Application by Alternative Use Boston Projects Limited for Boston Alternative Energy Facility
The Examining Authority's written questions and requests for information (ExQ1)
Issued on 14 October 2021

Responses are due by Deadline 2: Thursday, 11 November 2021.

TITLE
**GENERAL LAYOUT DRAWING PLAN
FIGURE 5.1 - SHEET 1 OF 2**

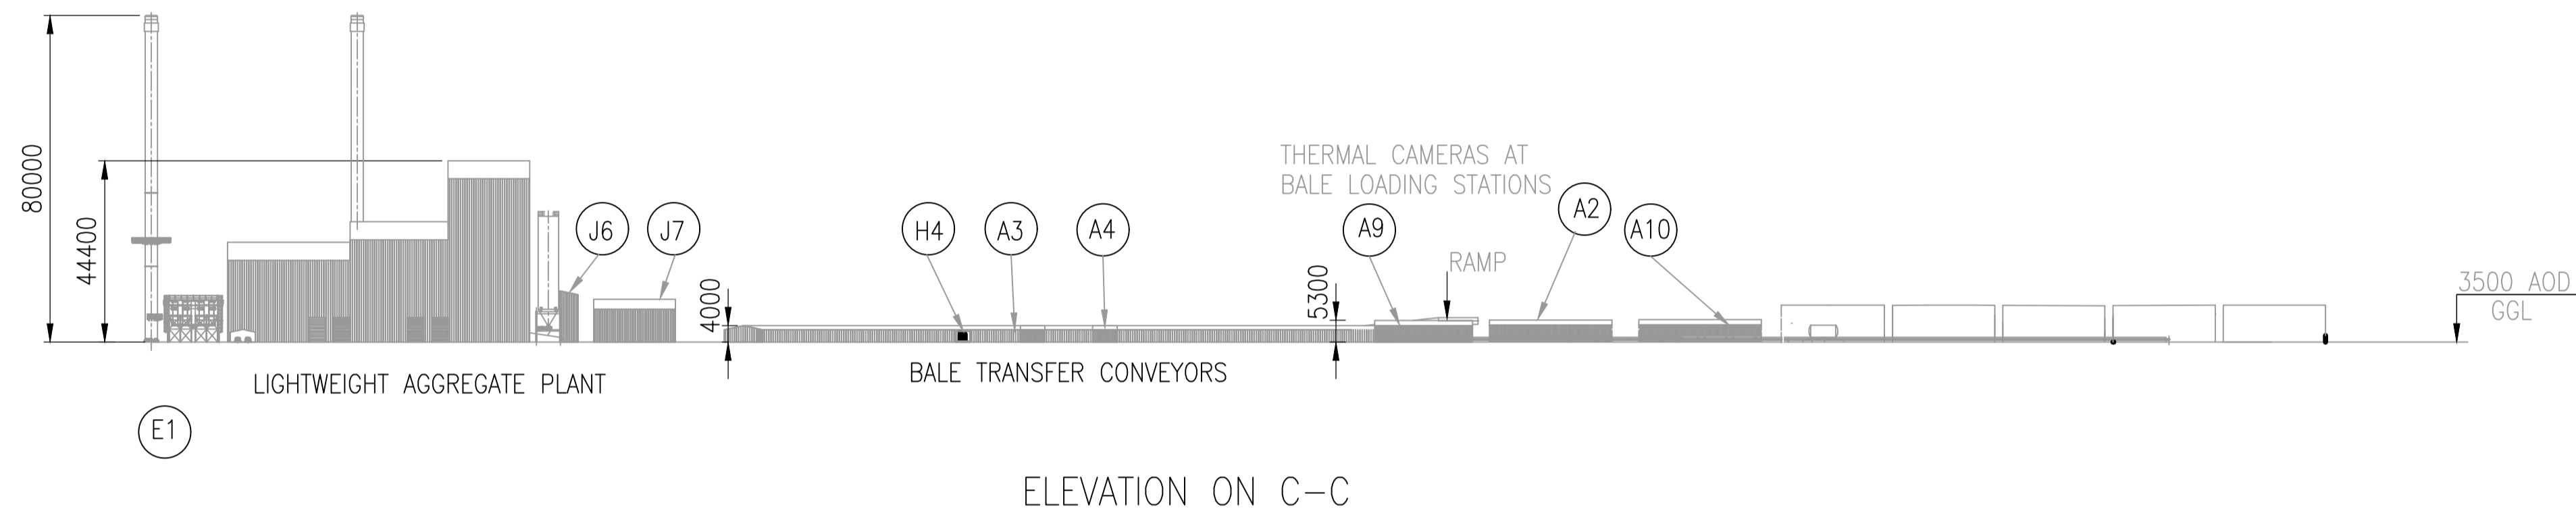
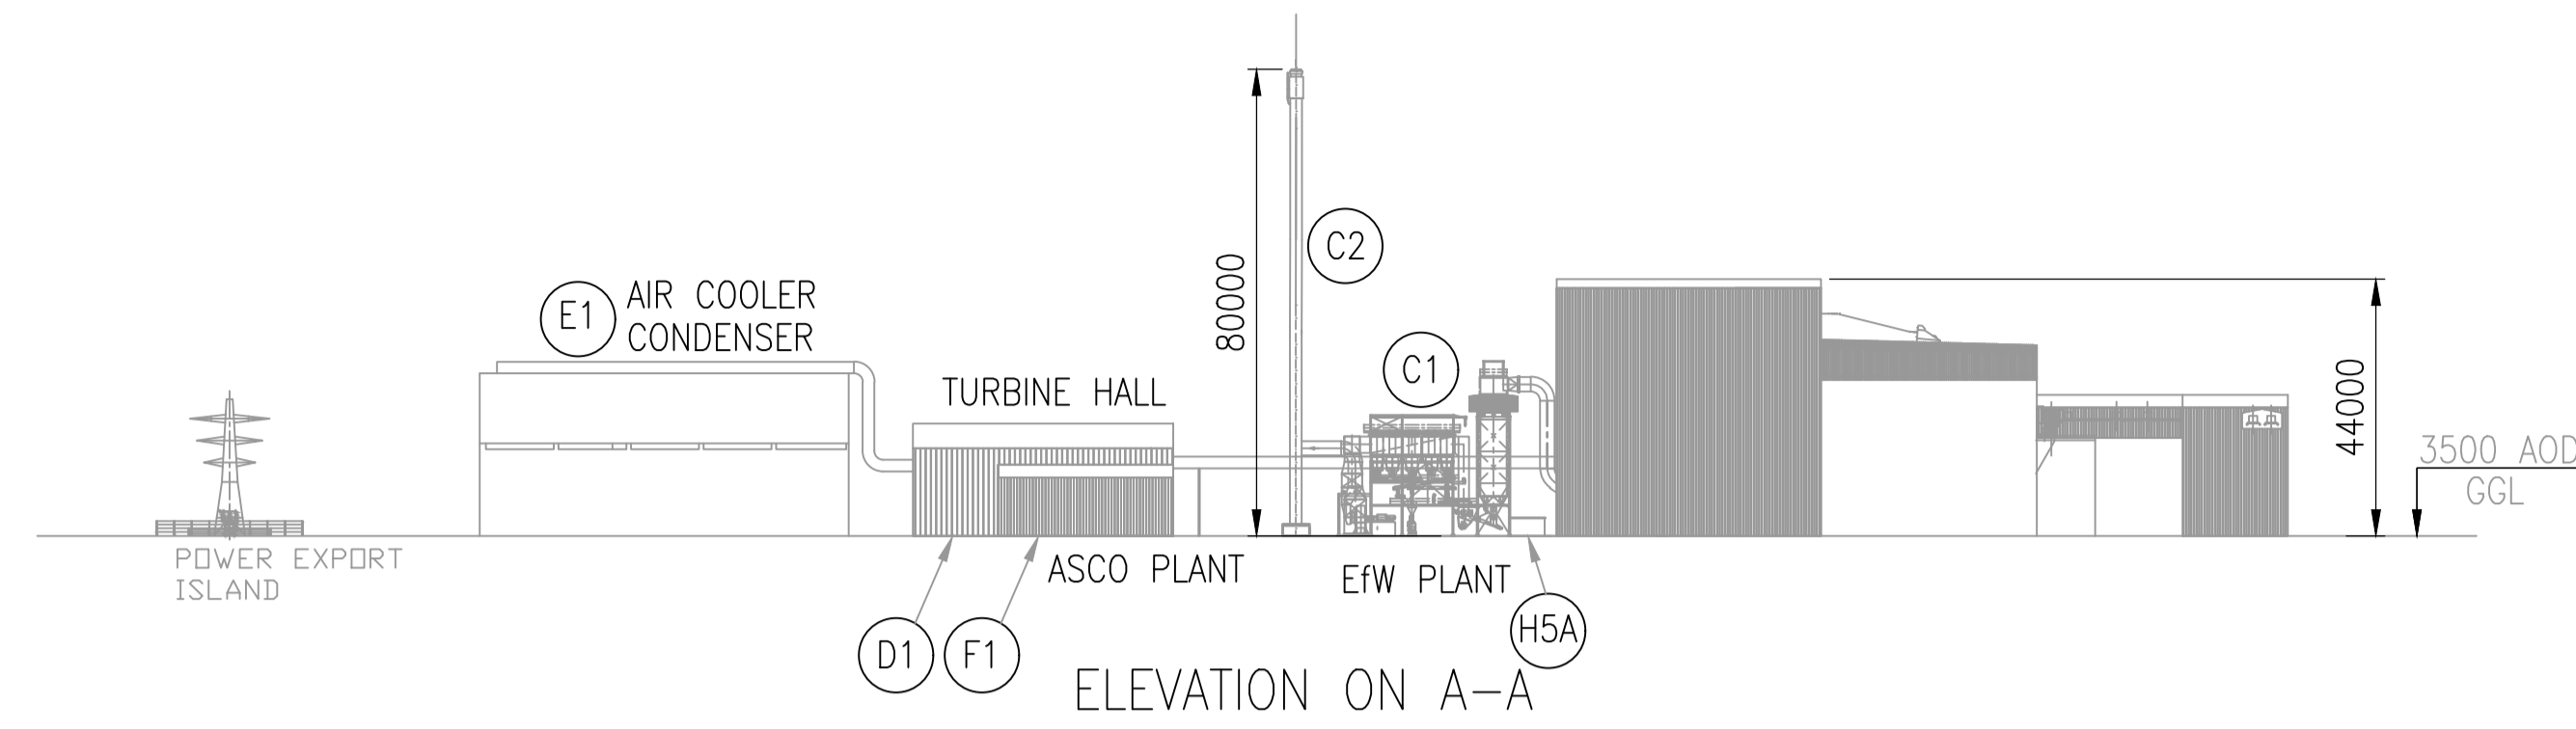
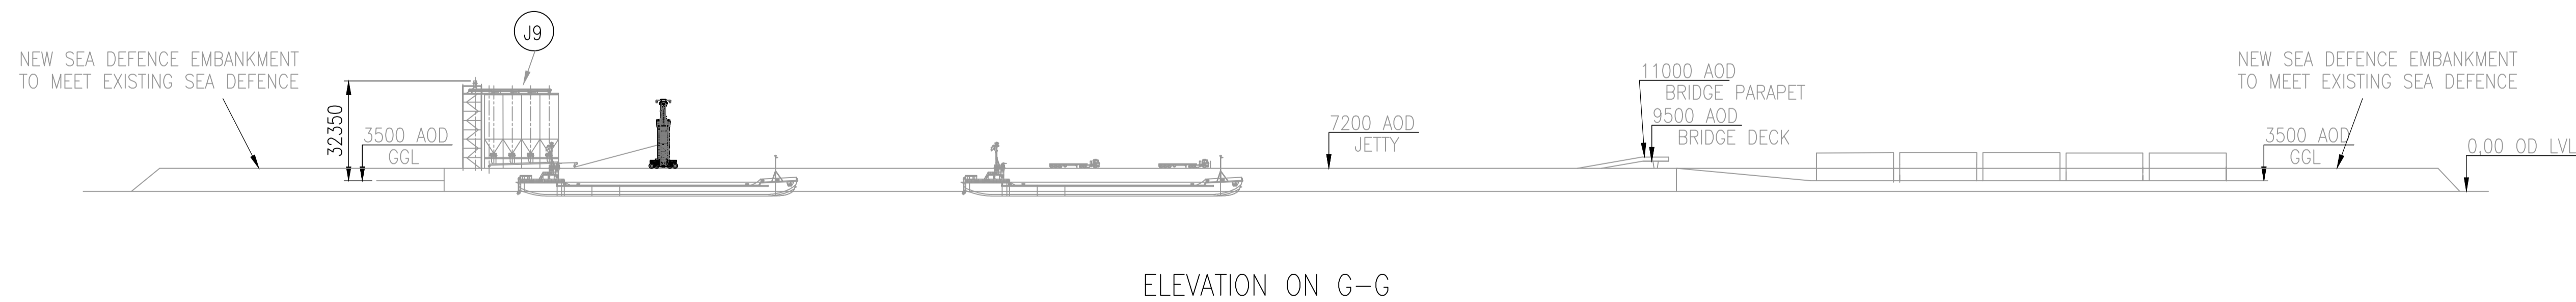
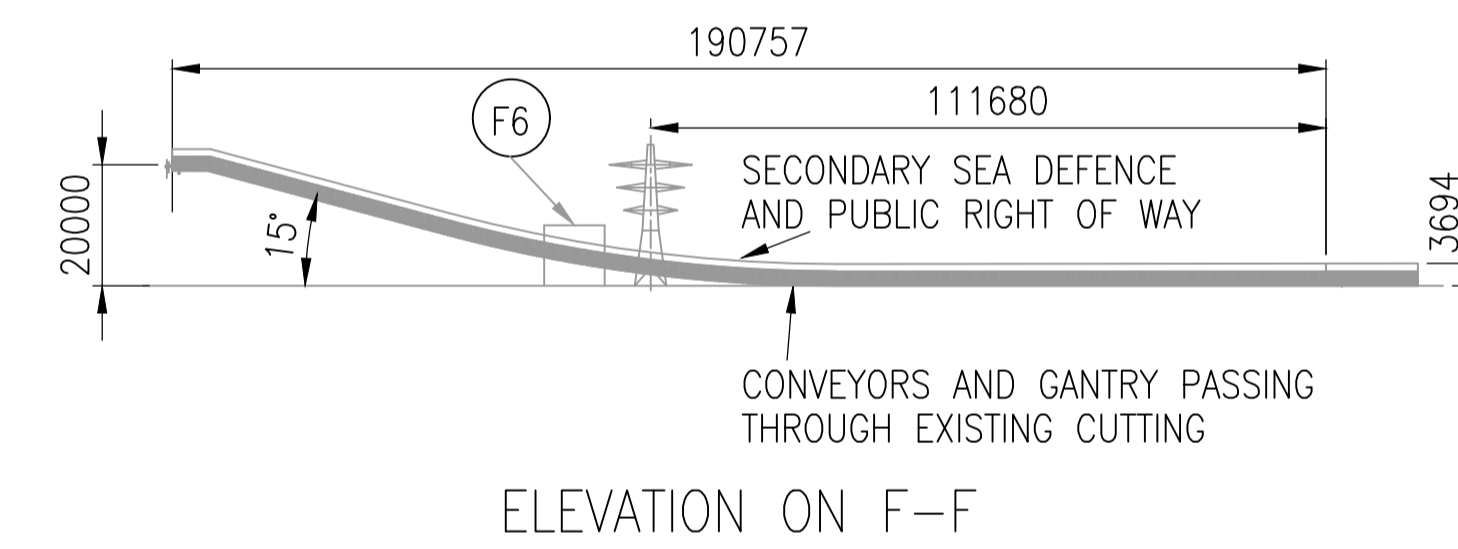
Q3.0.8	The Applicant	ES Chapter 5 paragraph 5.6.28 states that a quarantine area would be provided in the damaged bale store for any detected prohibited waste or bales found to be hot. However, a 'bale quarantine zone' and a 'damaged bale store' are shown in separate locations on ES Figure 5.1 (General Layout Drawing Plan). Please can the Applicant confirm the location of these elements.
Q3.0.9	The Applicant	I note that the Environment Agency (EA) state, in their RR, that they are unlikely to be in a position to provide any assurance before the end of the Examination on whether they can grant a permit for the Proposed Development. Please can the Applicant provide an update on progress with each of the Environmental Permit (EP) applications referenced in the ES. Please could it also confirm whether the applications include a bespoke application for the discharge of surface water during construction, as suggested in ES Chapter 5. If the Applicant considers that any of the EPs are not required, please detail what alternative form of protection are proposed to satisfy the EA's concerns.
